**Growth, Environment
& Transport**

12 September 2024

Re: Application for an Order Granting Development Consent for Stonestreet Green Solar – Relevant Representation Submission

Environmental Statement Figure 3.2:
Proposed Access Network
- Sheet 1 of 5

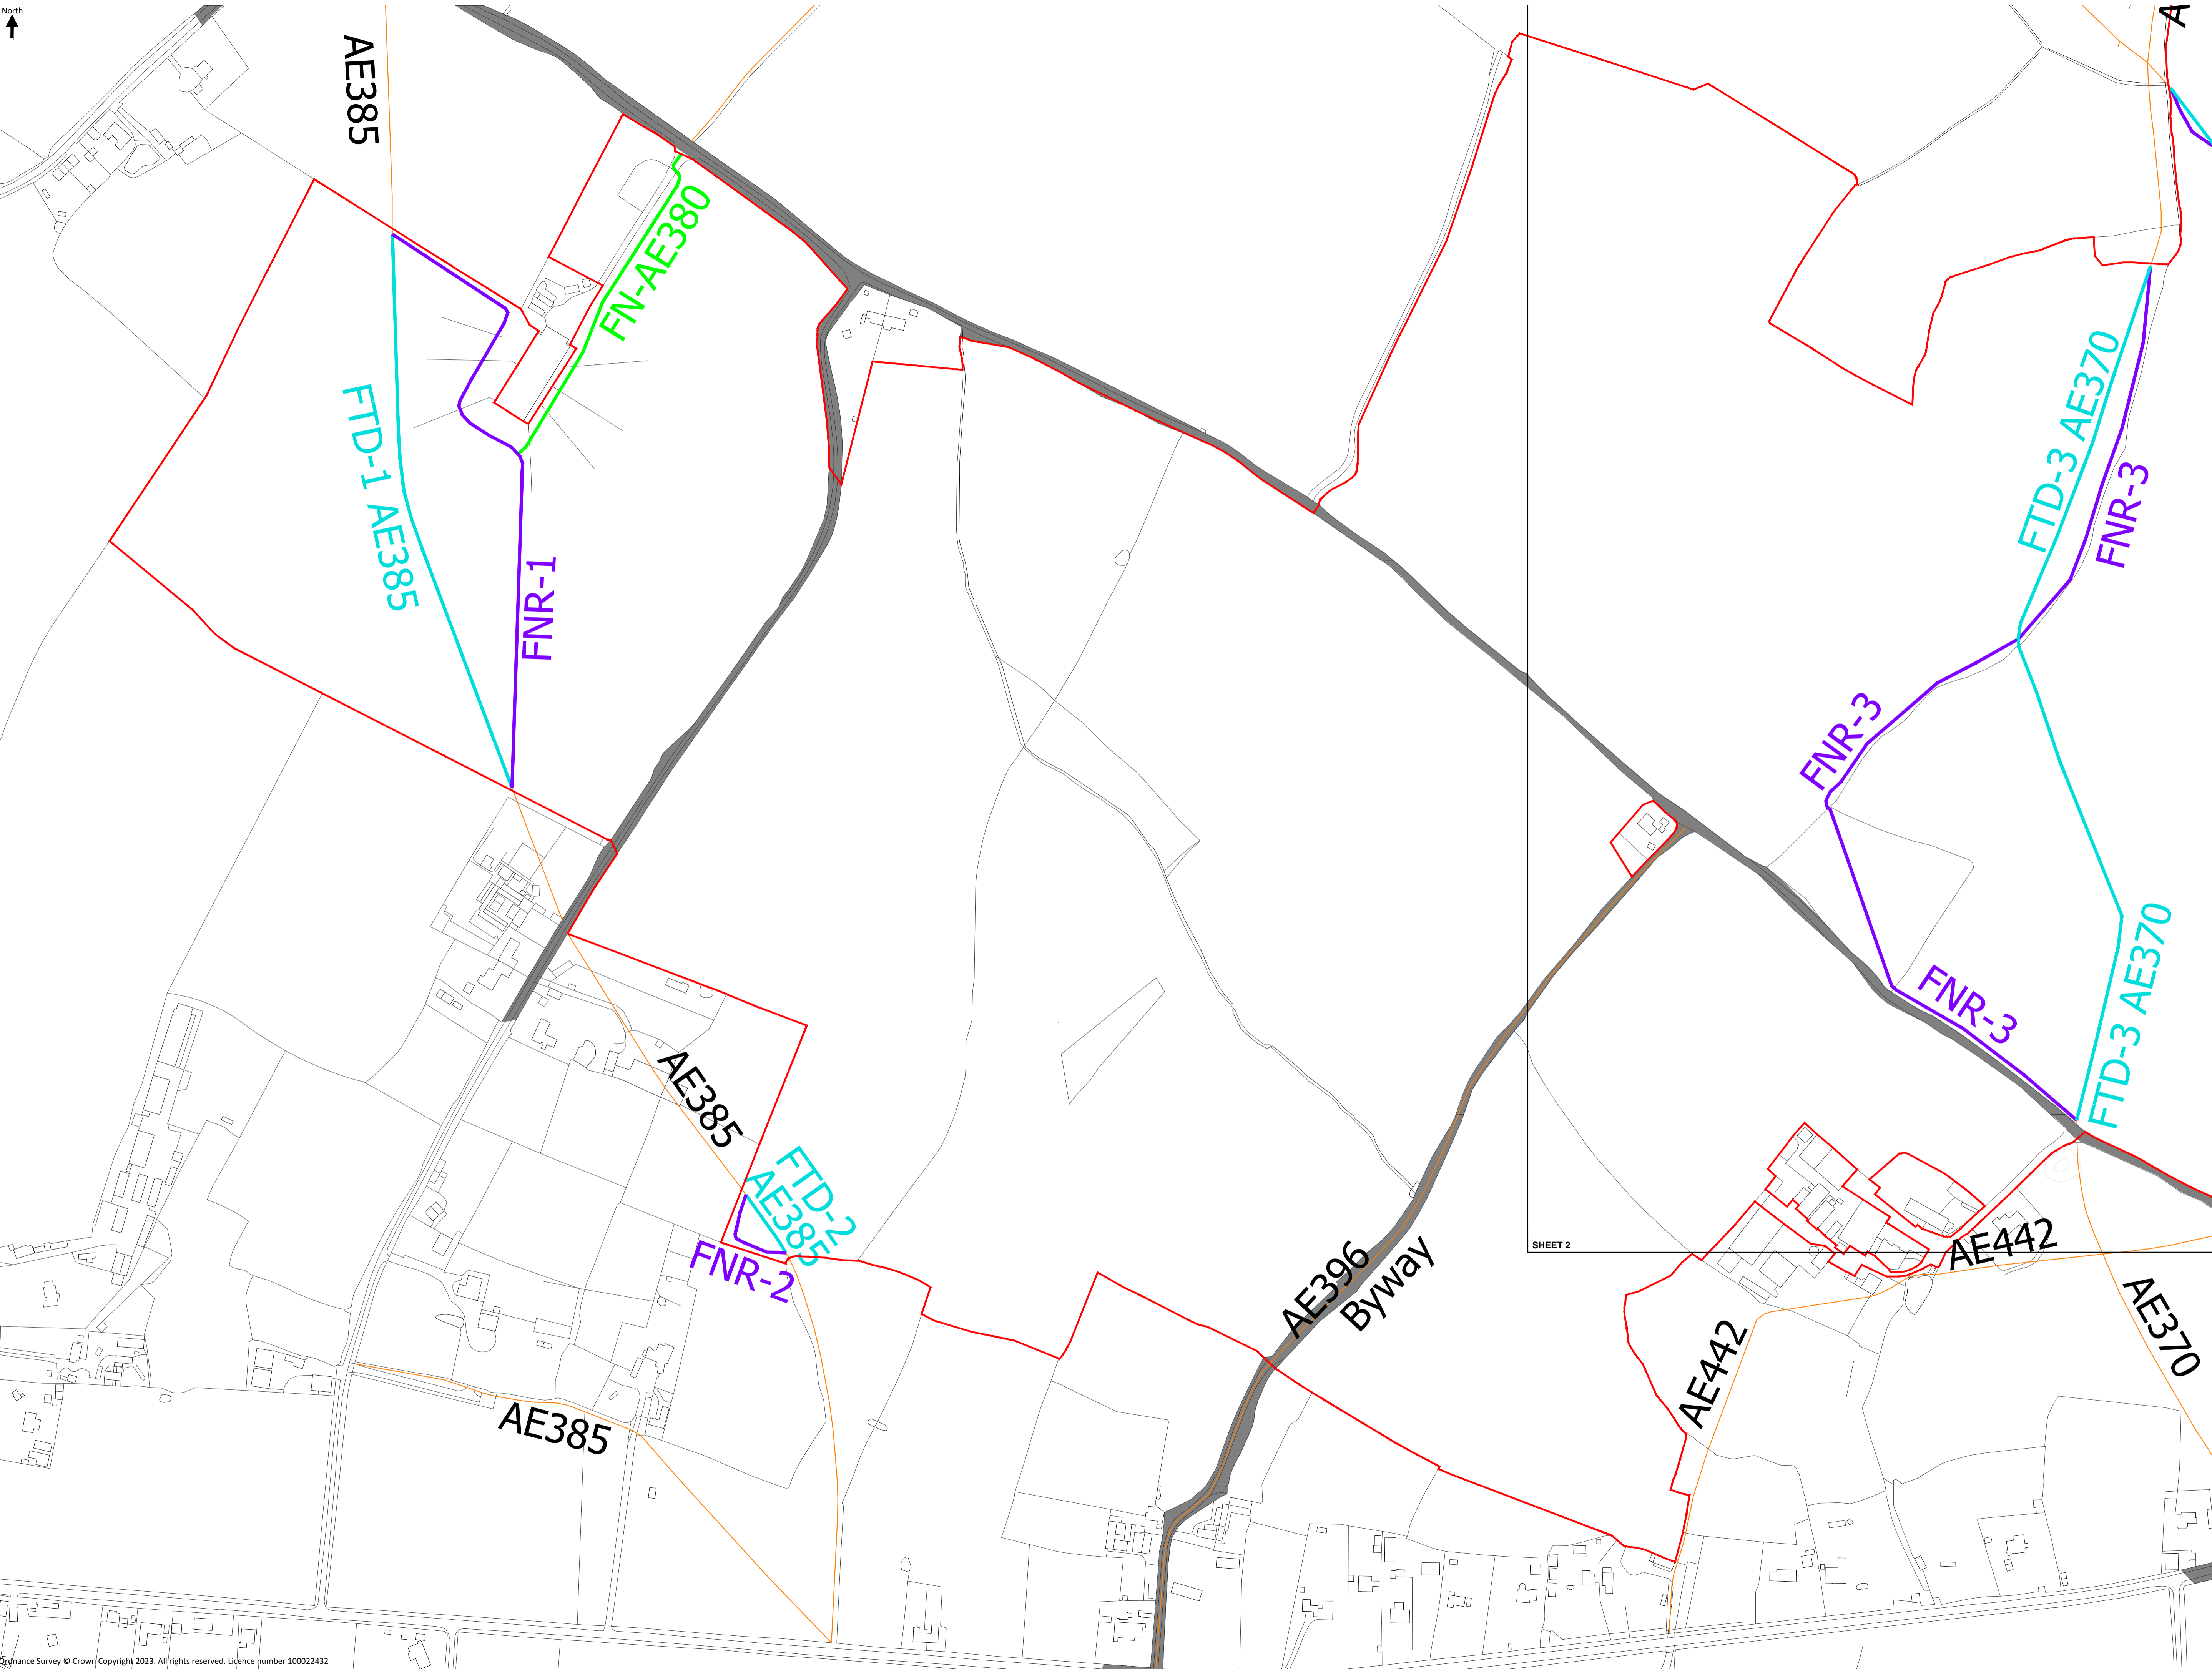
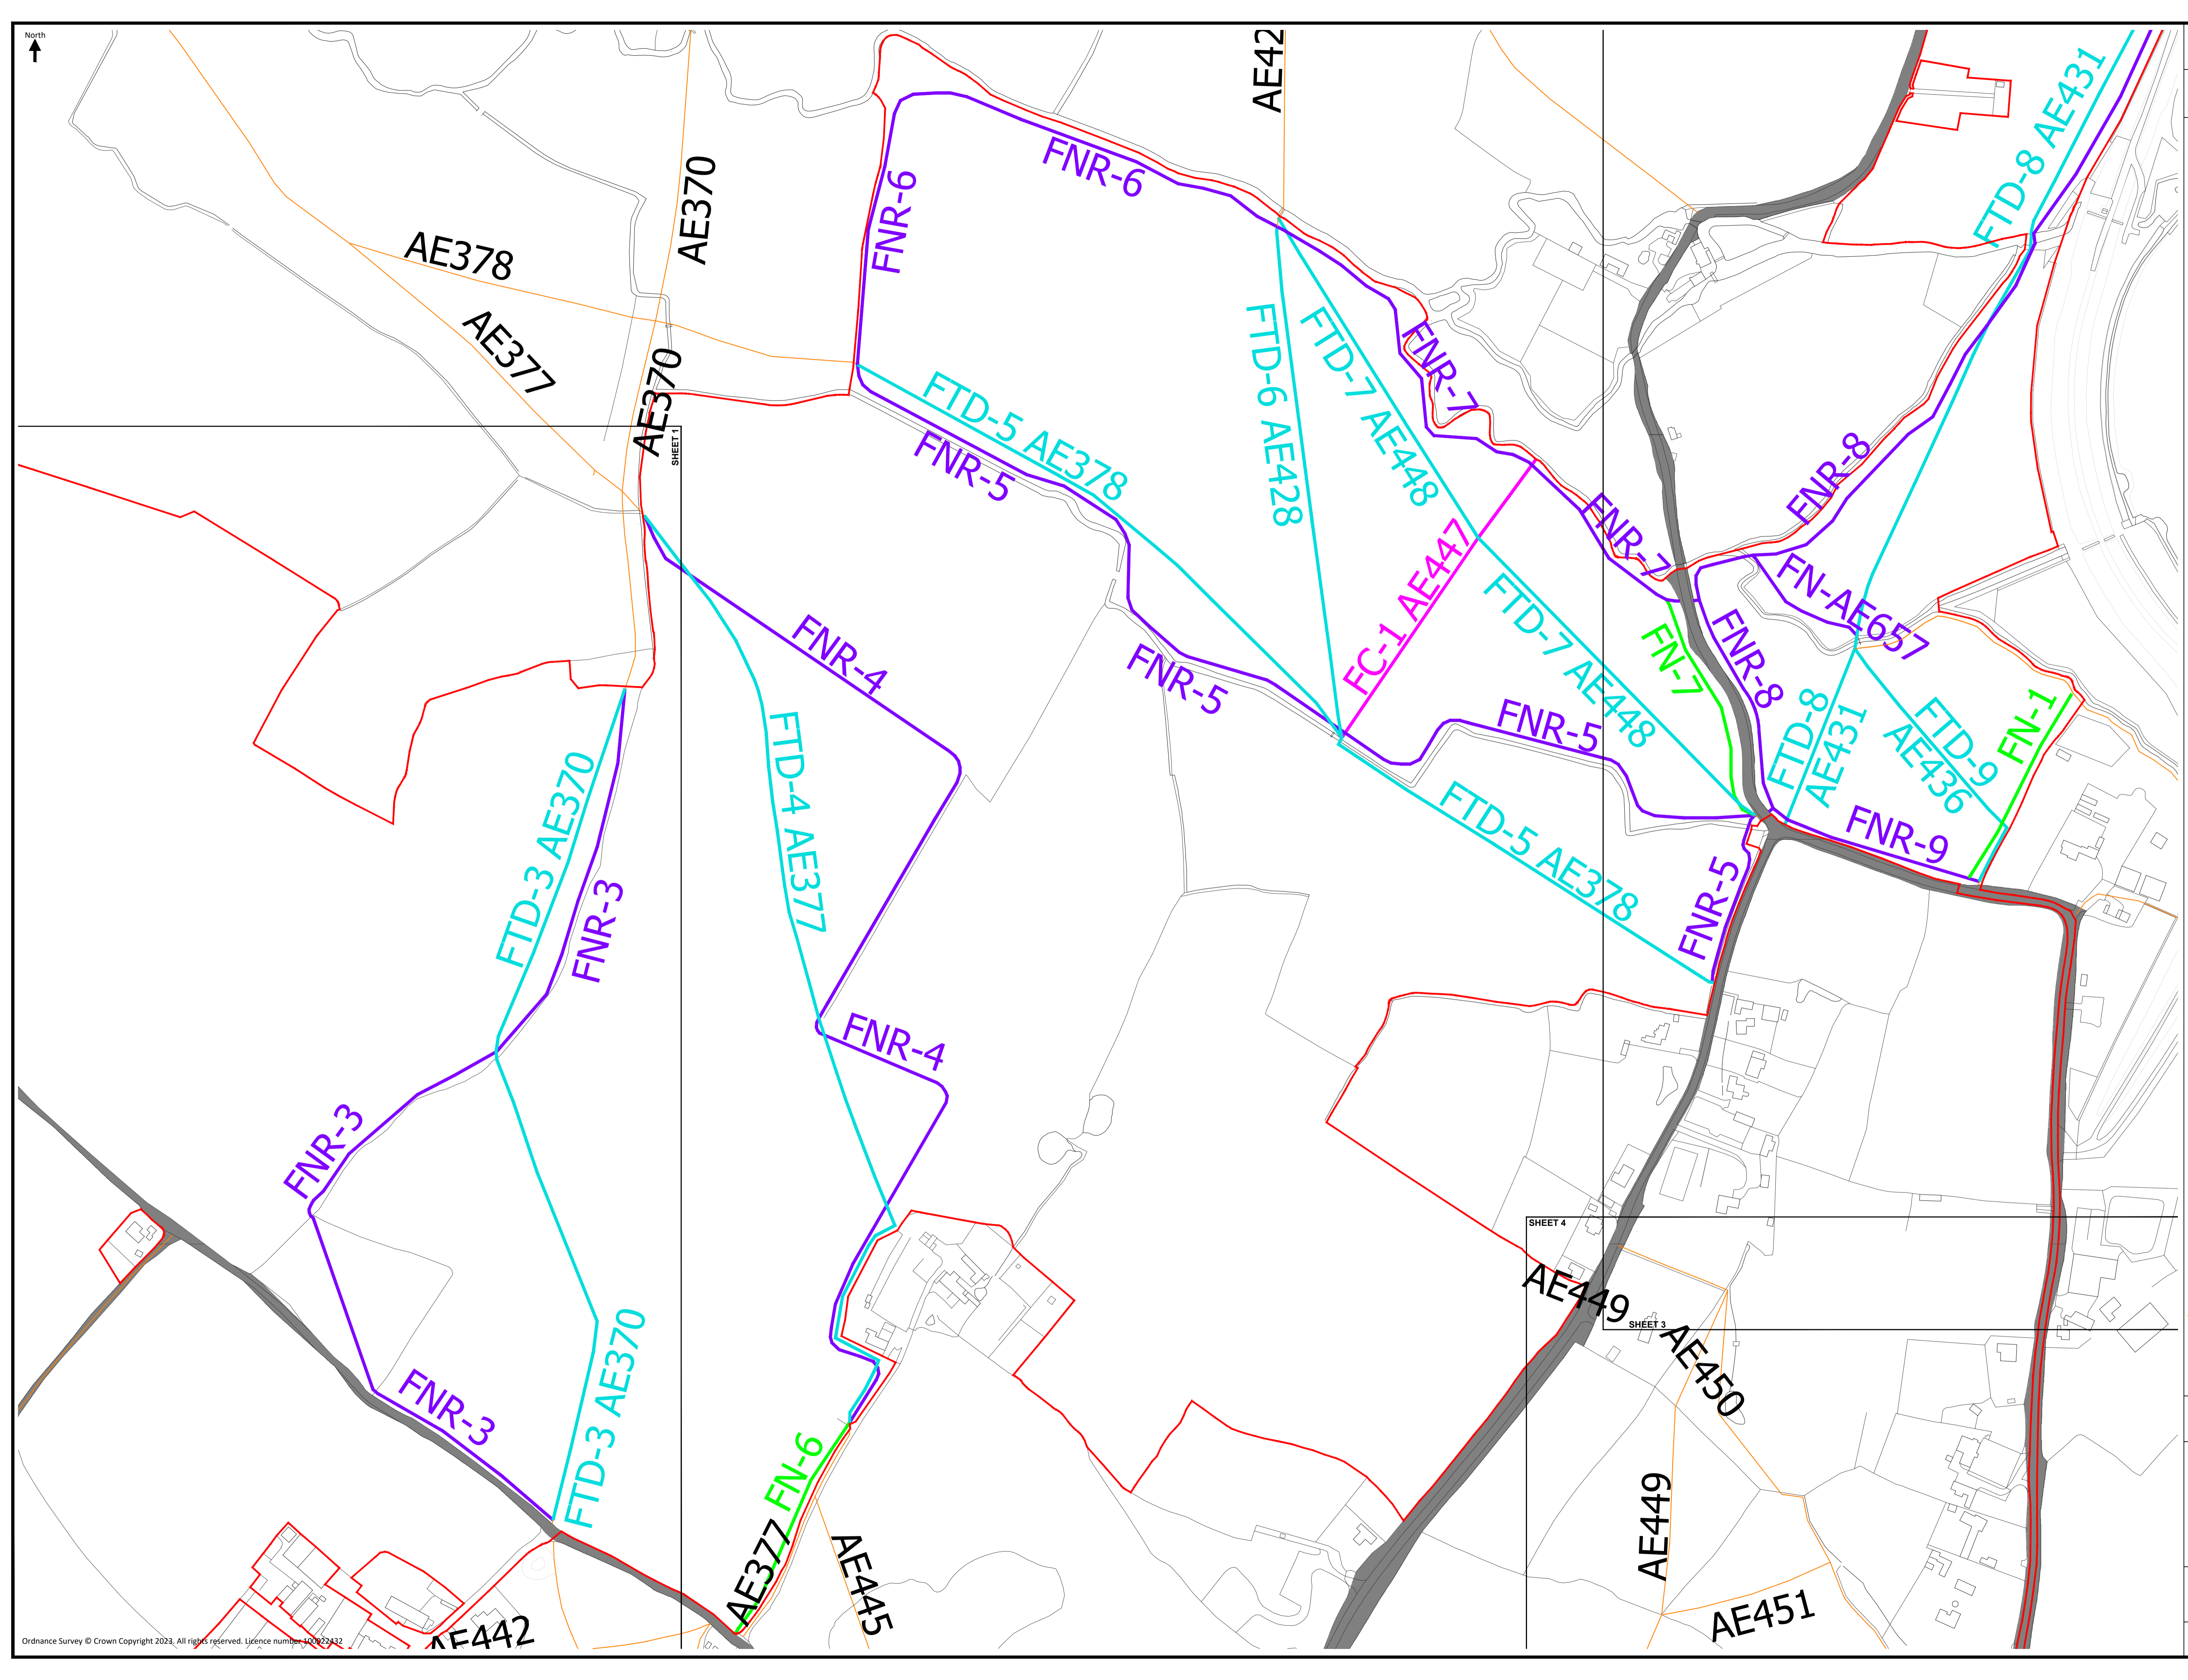
As part of the access strategy, to reach all of the plots to the south of Bank Road, the proposed routing as shown uses the existing access road to Bank Farm. Although the crossing of Bank Road itself can be undertaken via traffic management, the Bank Farm access road is already restricted in width and only wide enough for one-way working for vehicles. Visibility is not adequate from the southern end of the access road to the Bank Road junction to prevent conflicting movements. Any resulting reversing manoeuvres of large vehicles for both direct solar site traffic or other access users would not be welcomed. There are other business interests and access needs on Bank Farm and increased use of this access road with large vehicles with no improvements would not be sensible. Localised widening to the access road to allow for overtaking space, taking account of forward visibility, should be implemented. Revision/clarification on this issue is required by the County Council ahead of the commencement of the Examination.
